November 4, 2019

RE: Lazy Ed Ranch Boundary Line Adjustment (BL-19-00021) – Additional Information Requested

# LAZY ED RANCH SITE PLAN

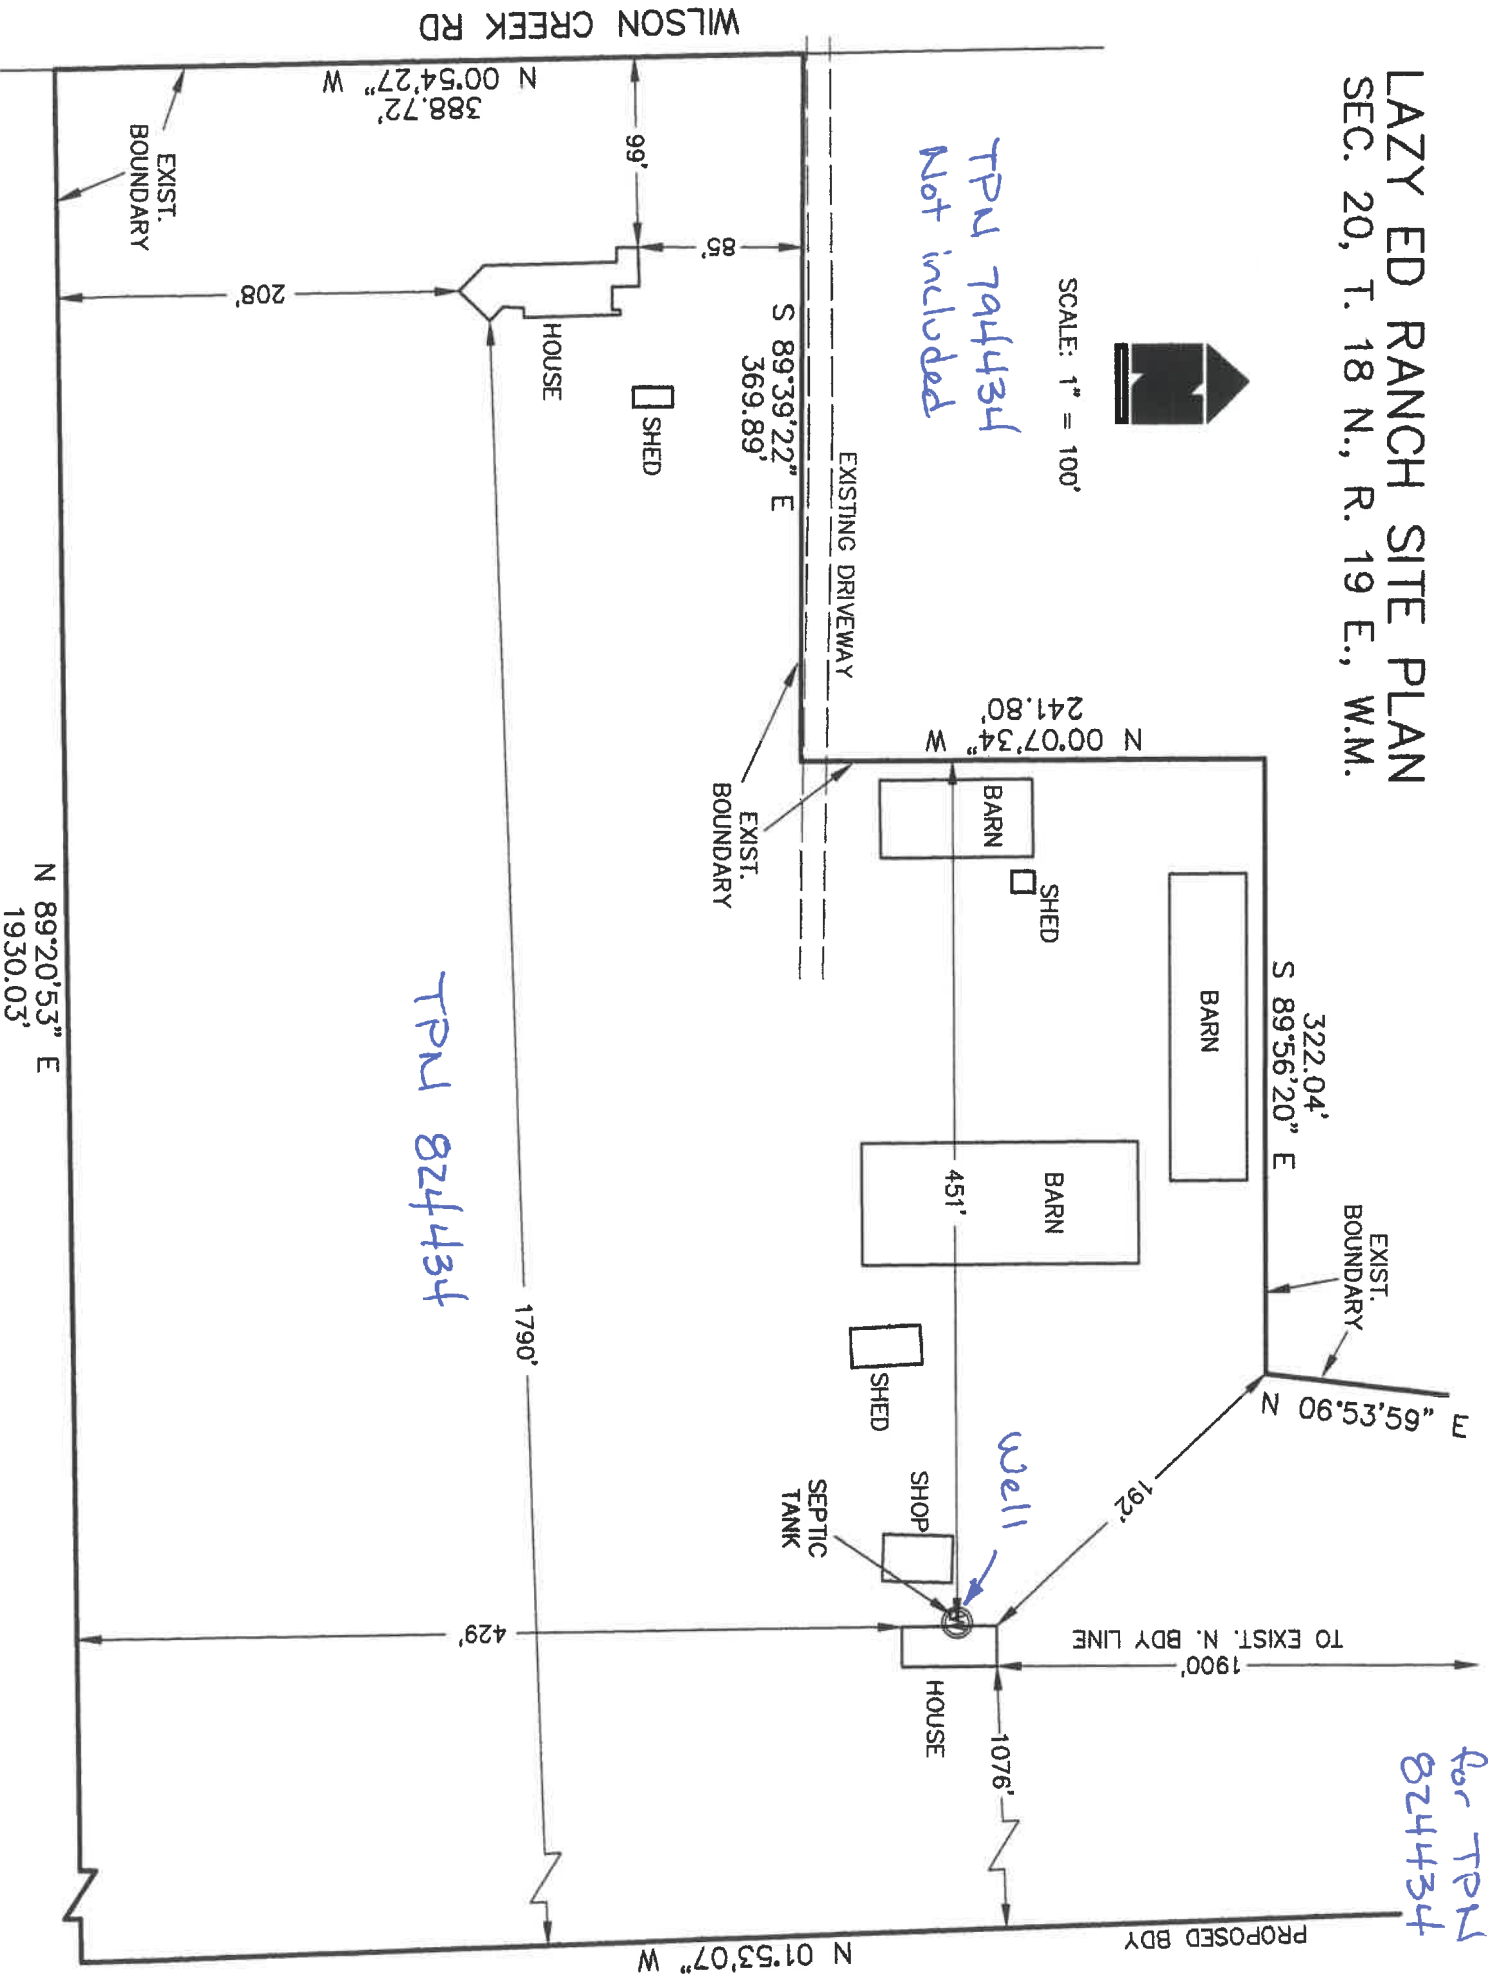
- An updated sitemap clearly showing the location of the well, septic and drainfield and their distances from property lines and structures.
- Ensure all required information requested by Public Works has been provided. Please see Public Works Comments attached.
